WEST SUSSEX COUNTY COUNCIL CONSULTATION

TO:	Arun District Council FAO: Mr. S. Davis
FROM:	WSSC - Highway Authority
DATE:	9 March 2022
LOCATION:	Land to the south of Ford Lane and east of North End Road Yapton BN18 0DS
SUBJECT:	Y/10/22/PL Erection of 15 No dwellings (including 4 No affordable units) with associated access, parking, landscaping, drainage and public open space (additional units to those approved under application Y/123/21/PL). This application may affect the setting of a listed building, affects the character & appearance of the Church Lane Conservation area, affects a Public Right of Way and is in CIL Zone 2 and is CIL Liable as new dwellings.
DATE OF SITE VISIT:	n/a (visited previously for other applications on the site)
RECOMMENDATION:	More Information Required
S106 CONTRIBUTION TOTAL:	TBA

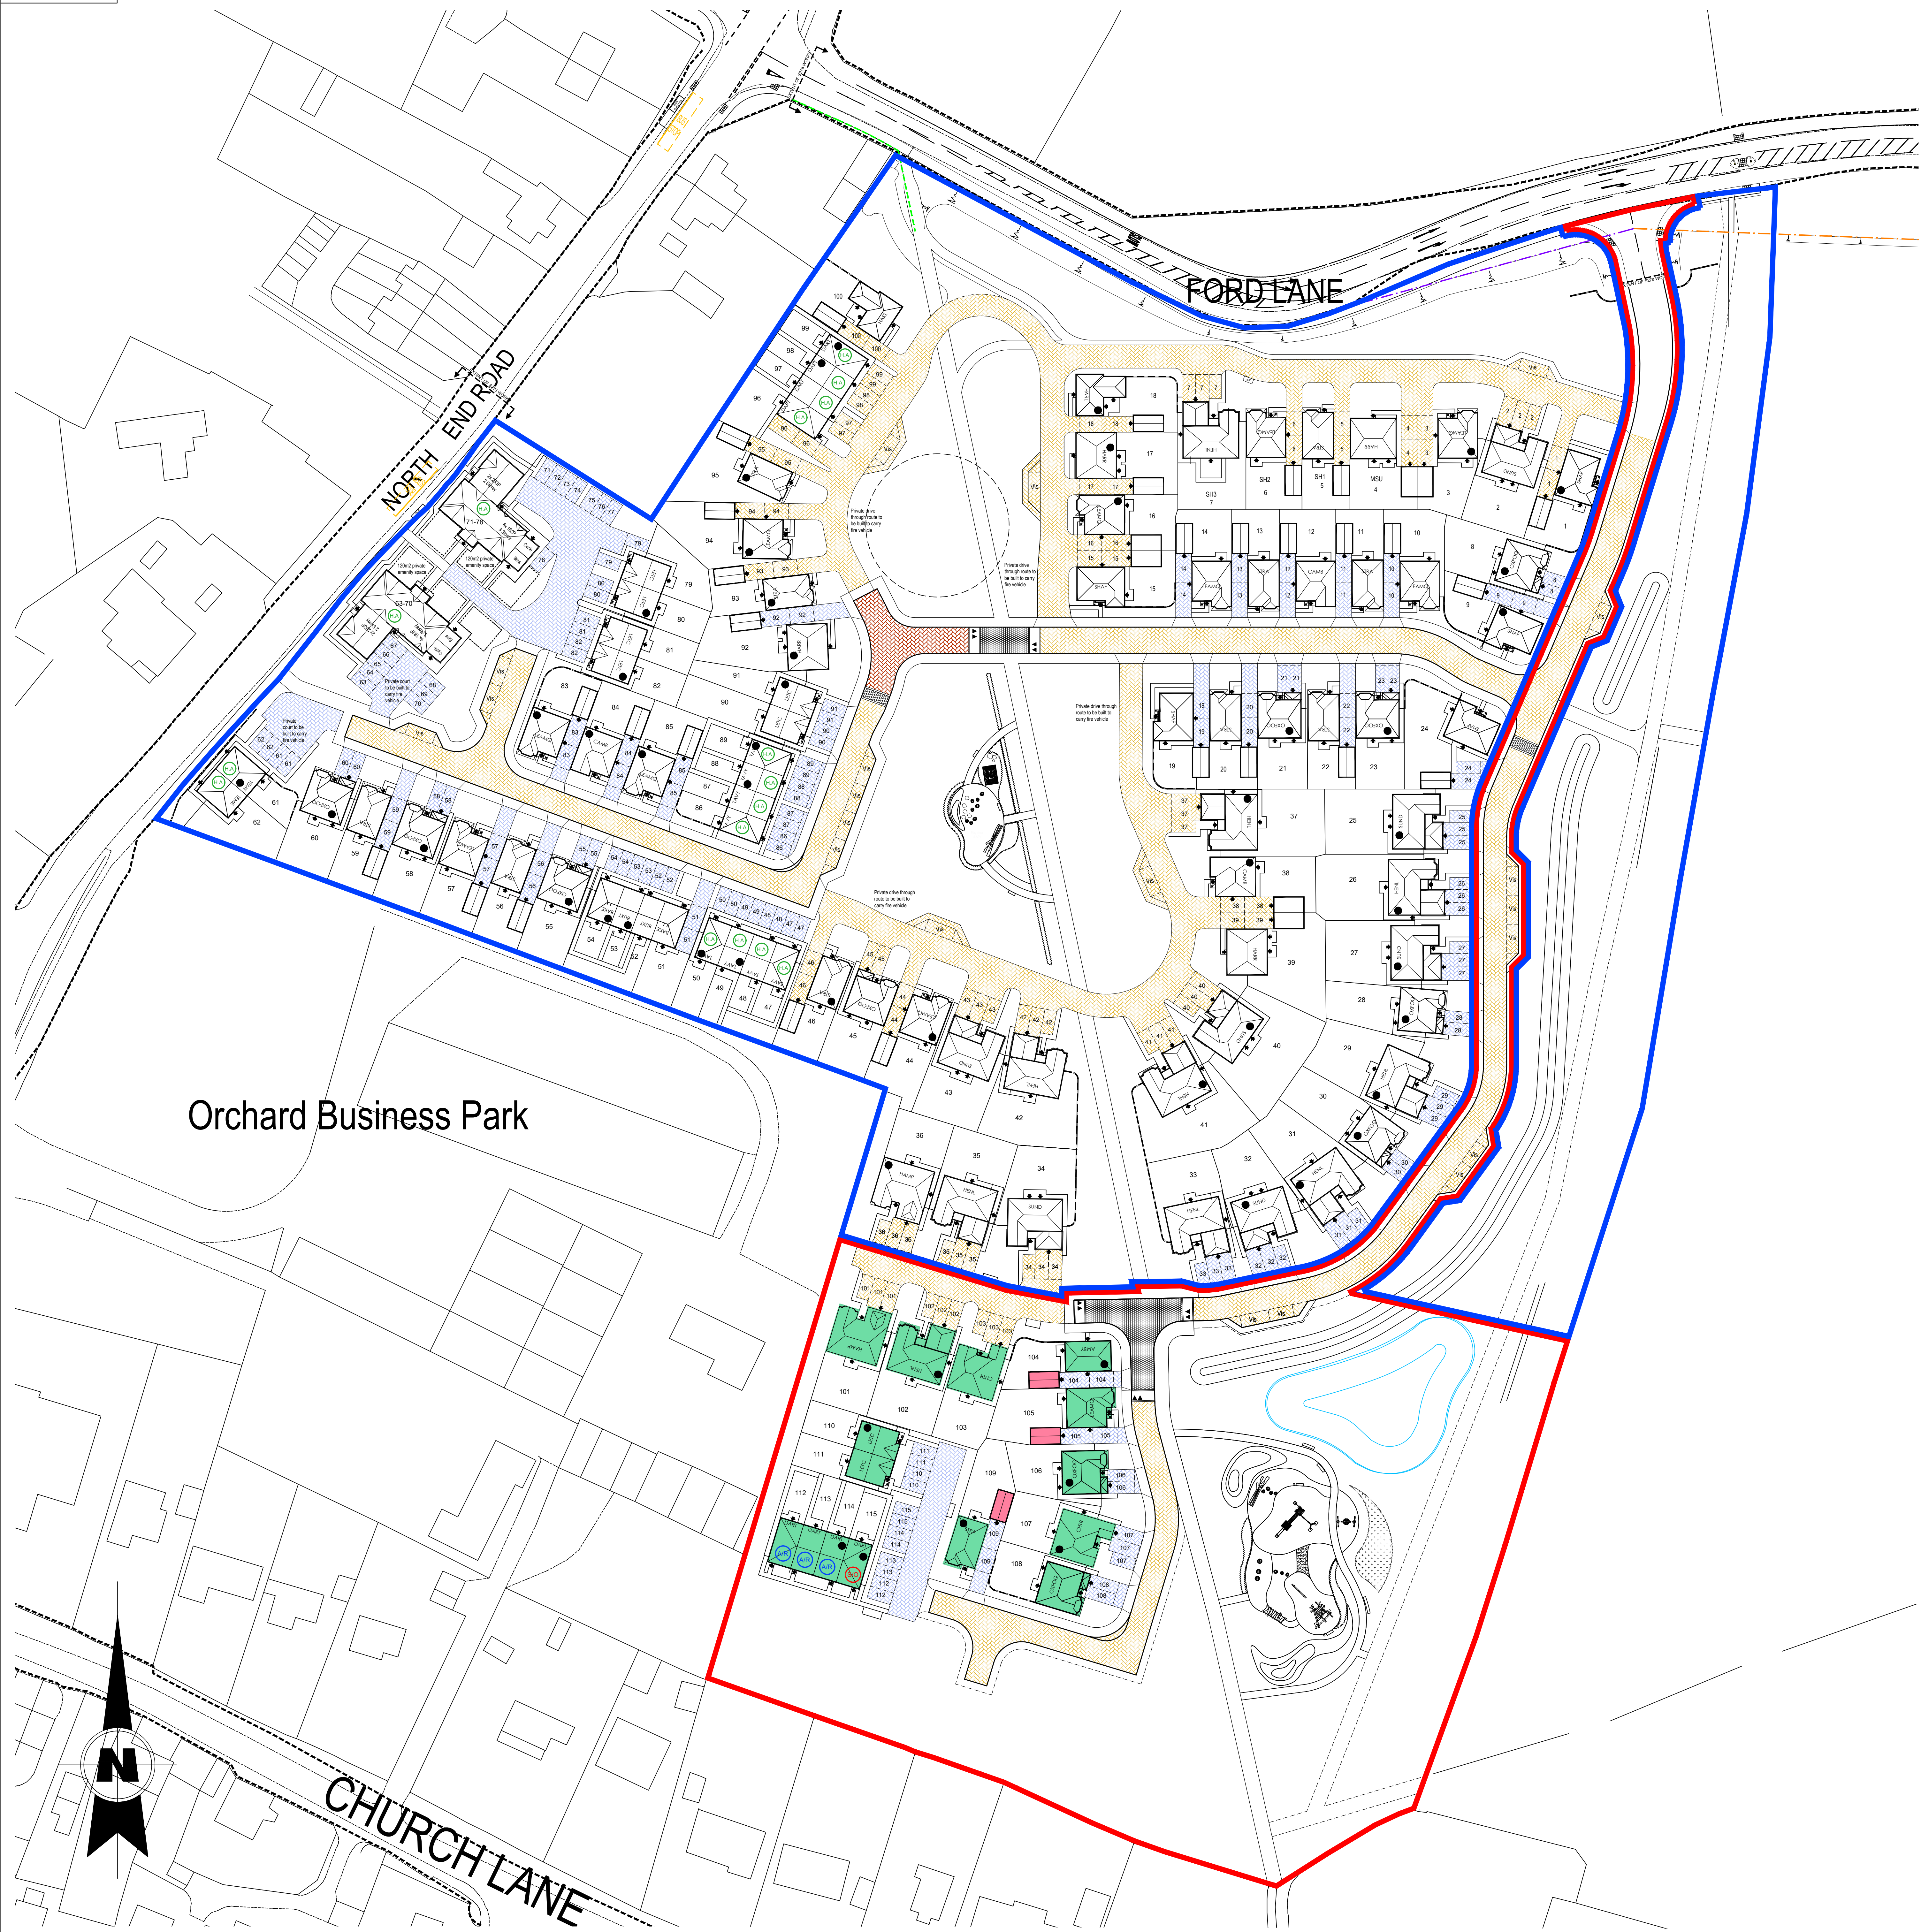
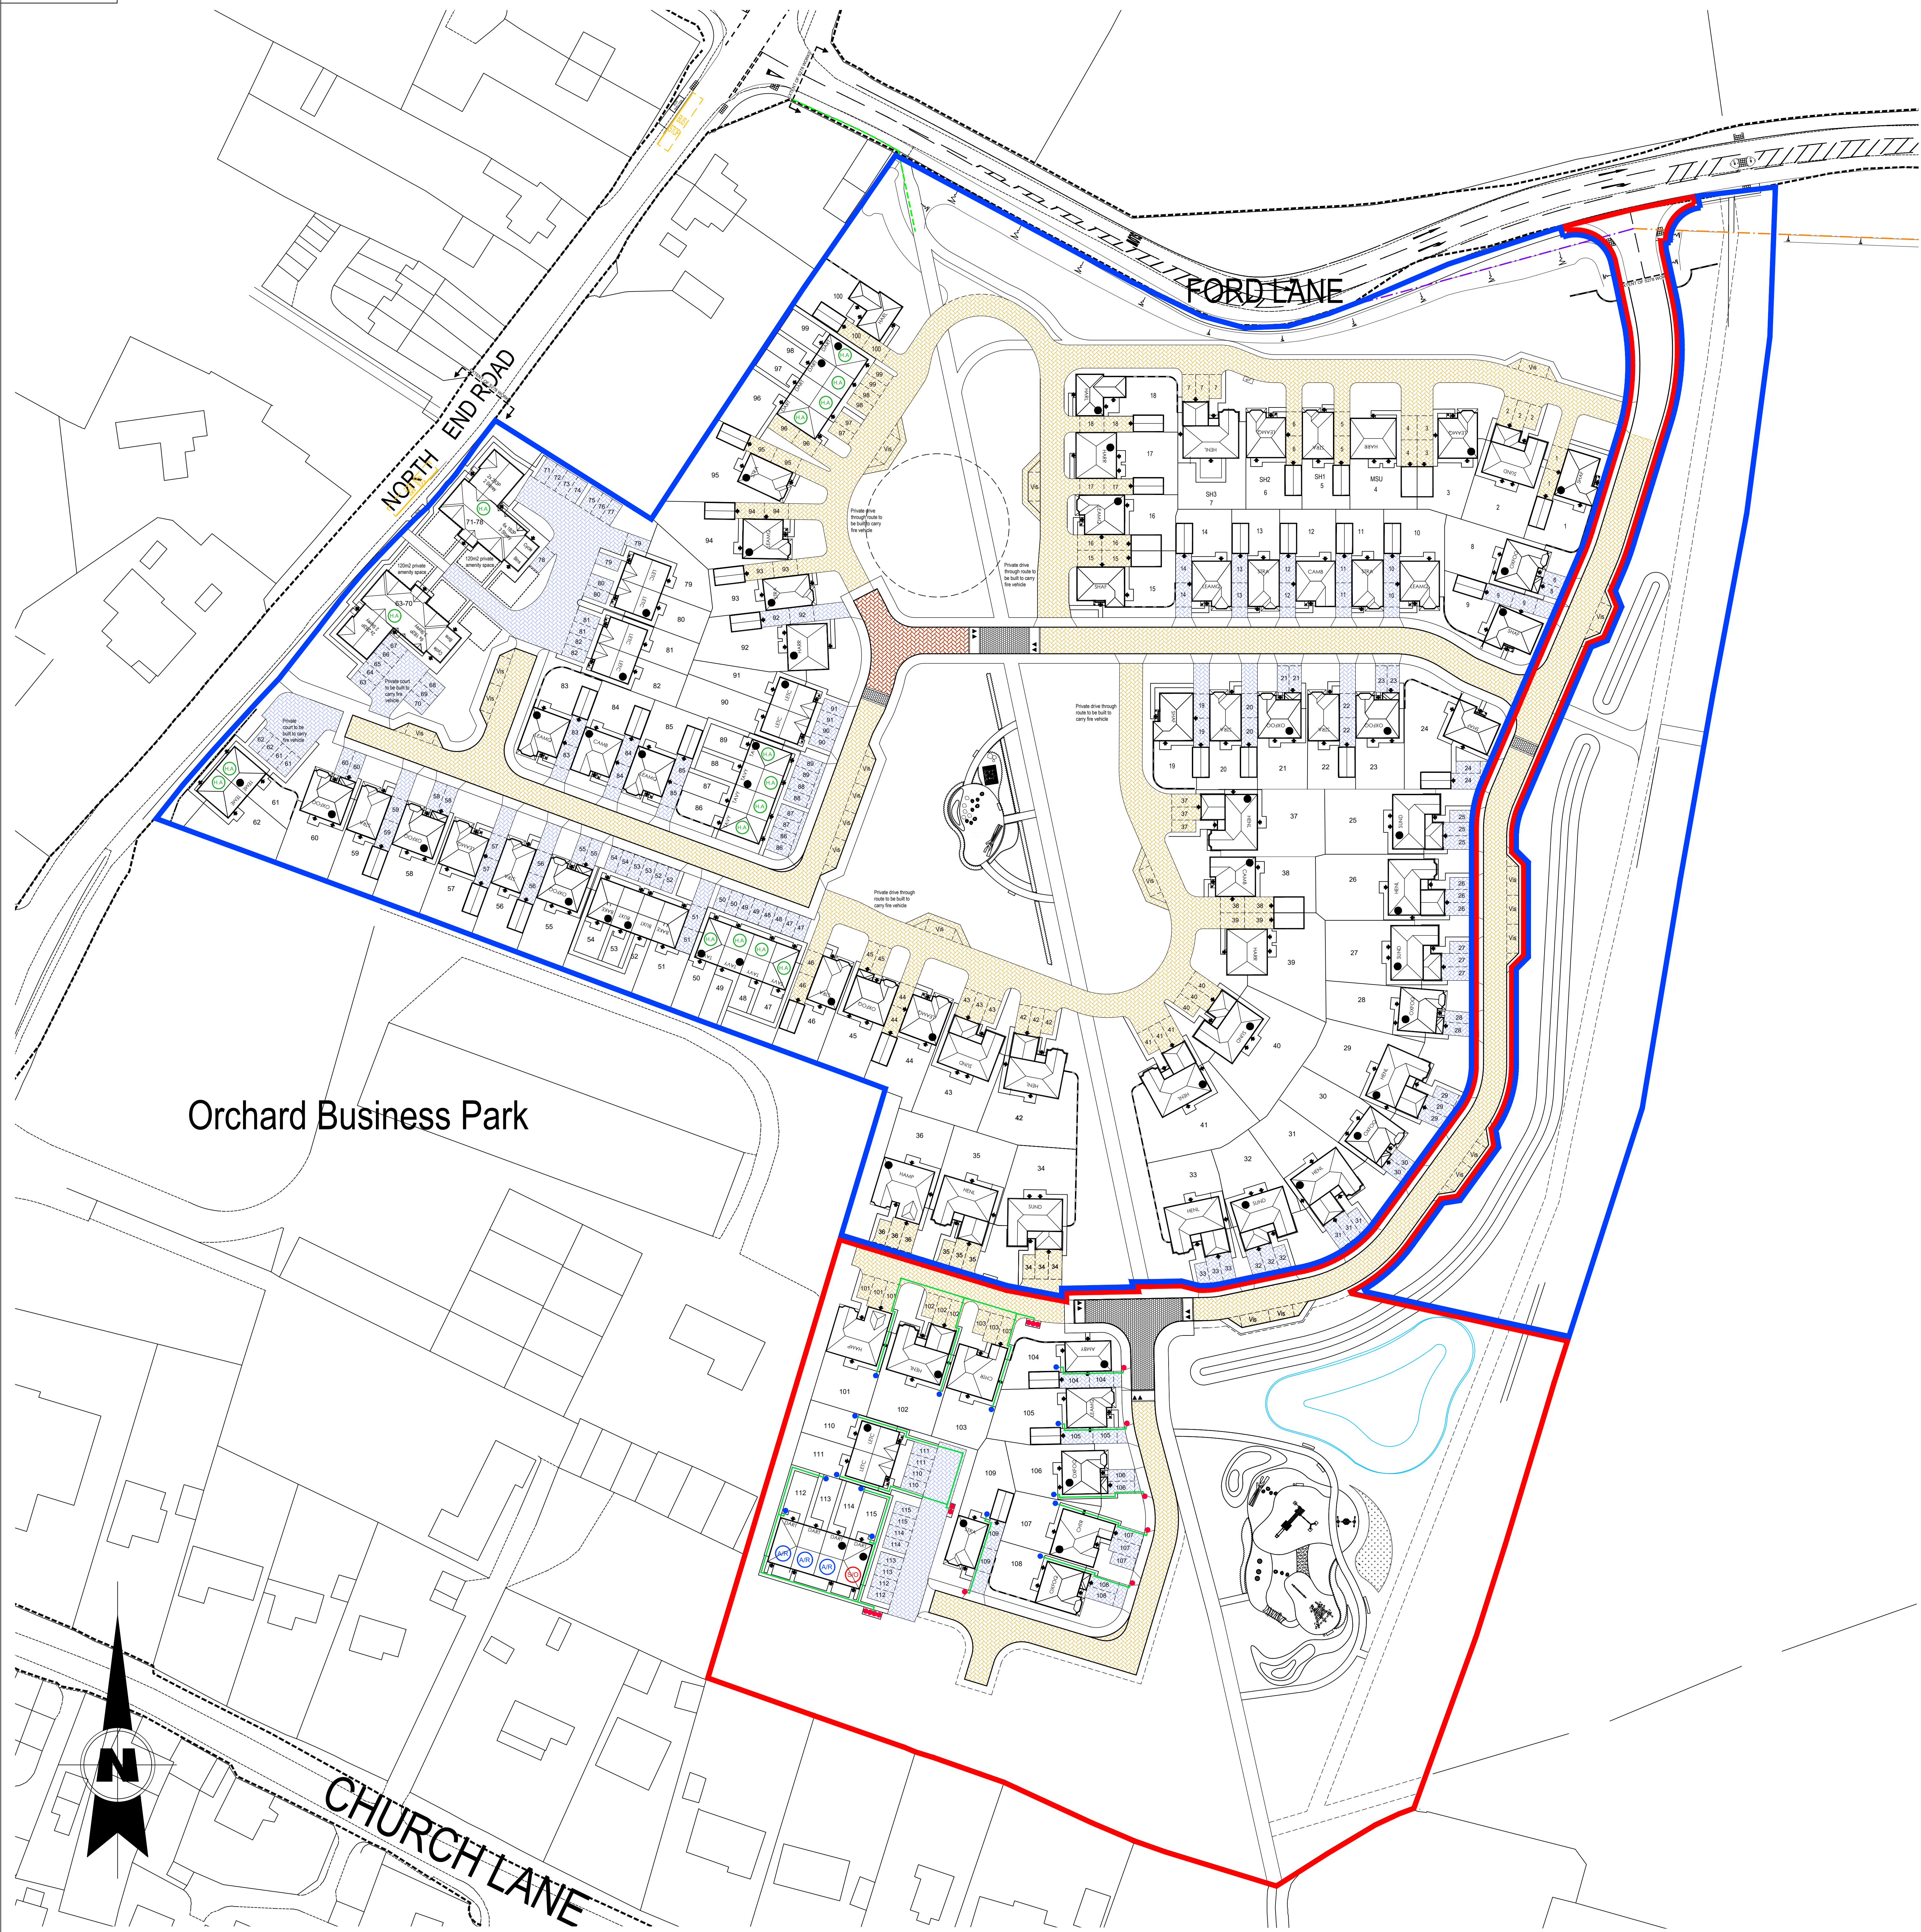
However, turning to this latest application, the turning head is now shown eastwards and again across the legal line of Public Footpath No. 357, thereby raising the previous CHA concern about future upgrading. As such, the CHA requests that the applicant re-visits this and provides an alternative that would allow for future upgrading of the Footpath to Bridleway and/or cycle path.

Parking - No visitor parking is shown provided for the new homes. Applicant to provide this.

Manoeuvring for cars - Width of manoeuvring area behind spaces serving plots 101-103 looks to be less than 6.0m. Applicant to show that a minimum dimension of 6.0m will be provided to assist vehicles entering and leaving parking spaces.
